Application number: 2020/93859	
What is the application for?:	Erection of single storey extensions and dormer windows to front and rear to for
Address of the site or building:	56, Stile Common Road, Primrose Hill, Huddersfield, HD4 6DE
Postcode:	HD4 6DE

Type of comment: A general comment
As a direct neighbour of the property under development, I raise the following comments about application 2020/62/93859/W at 56 Stile Common Road, HD4 6DE: House I raise no objection to the development of the house as planned. Garage building I make the following observations regarding the development of the new two-storey garage building and feel I have no just cause for objection if there are controls addressing these concerns: Firstly, the size of the stone building with an office/storage above the garage, is notably large in its proportions. Its position presents the possibility of shading some sunlight from the side of my property and particularly through kitchen windows at the side door. However, developed according to plan, I estimate the lower ground elevation of the site beneath the boundary retaining wall, the height of the building as drawn and the distance from the boundary will keep t

Proposed site plan (1:200)

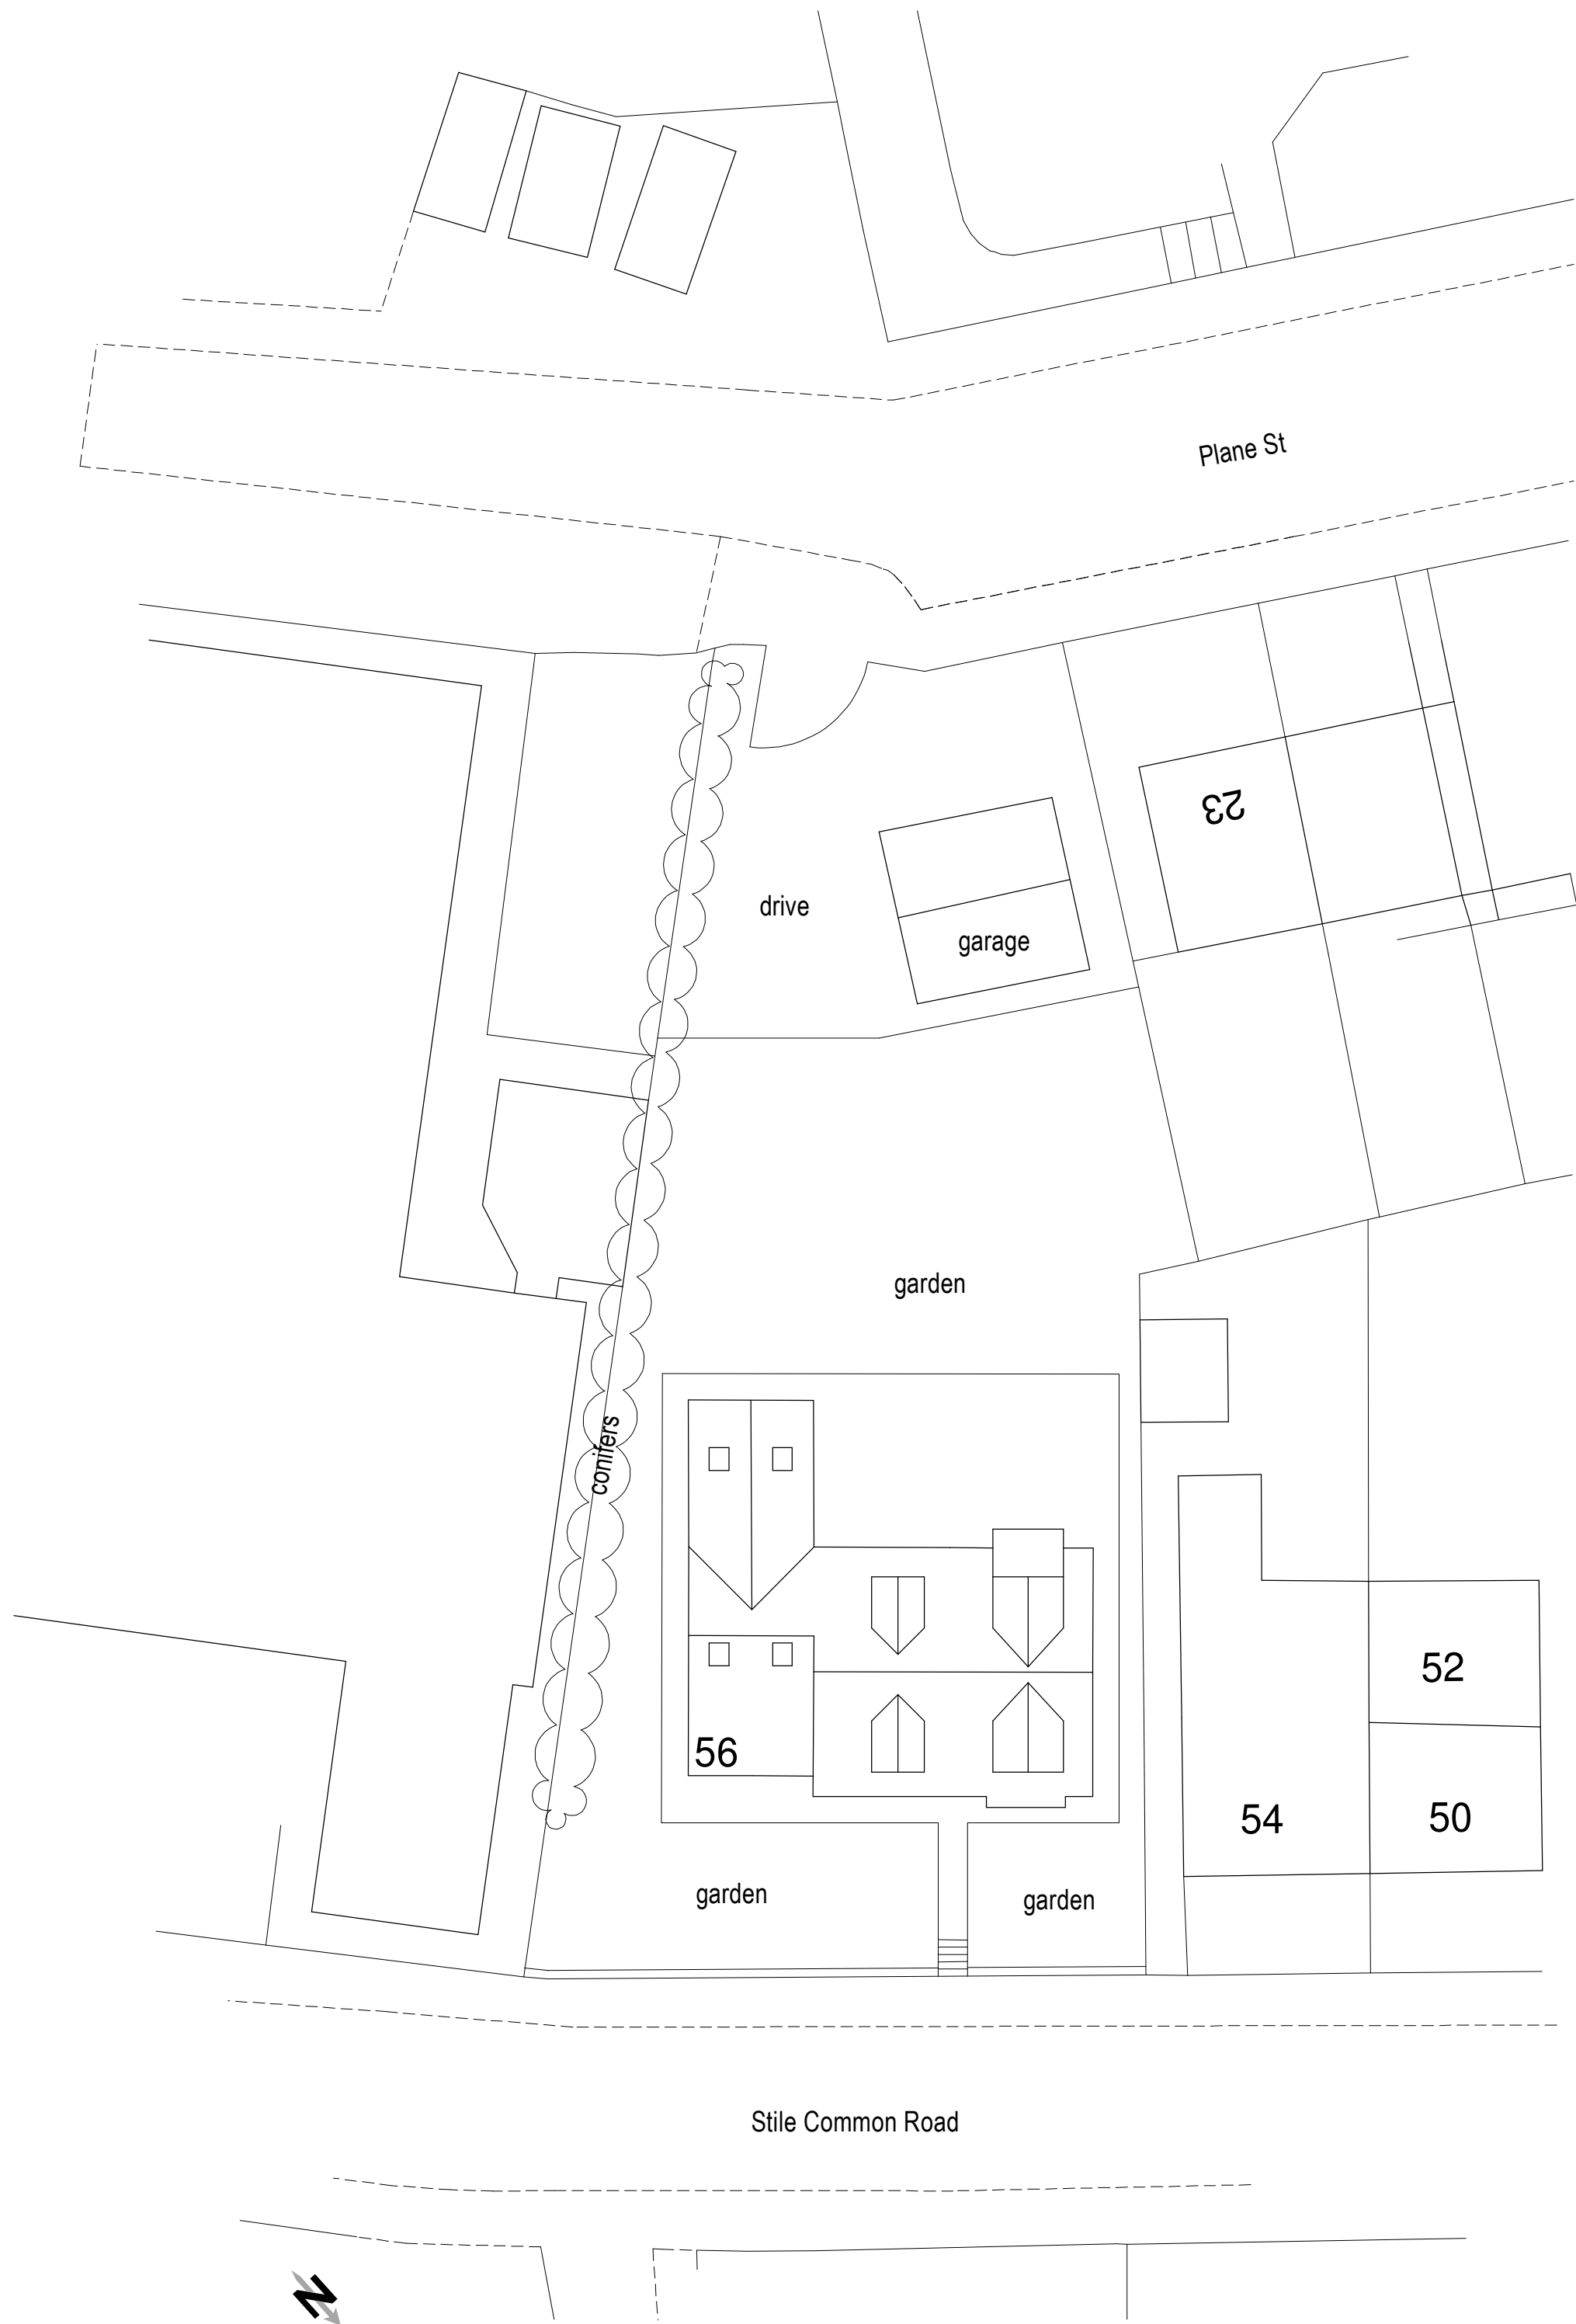
The plan here shows non-inclusion of the "trees and foliage" in the proposal drawing, however the applicant's form indicates 'No' to the question of "Will any trees or hedges need to be removed or pruned to carry out your proposal?"

I would like to see some control of this through the planning process, if possible. In particular, the removal of the Leylandii conifer tree high hedges next to the boundary of 23 Plane Street. These would become much more difficult to manage for their fast-growing height in the space between the proposed new garage building and boundary wall. Notwithstanding this, the planting of garden boundary vegetation of manageable proportions would be welcomed.
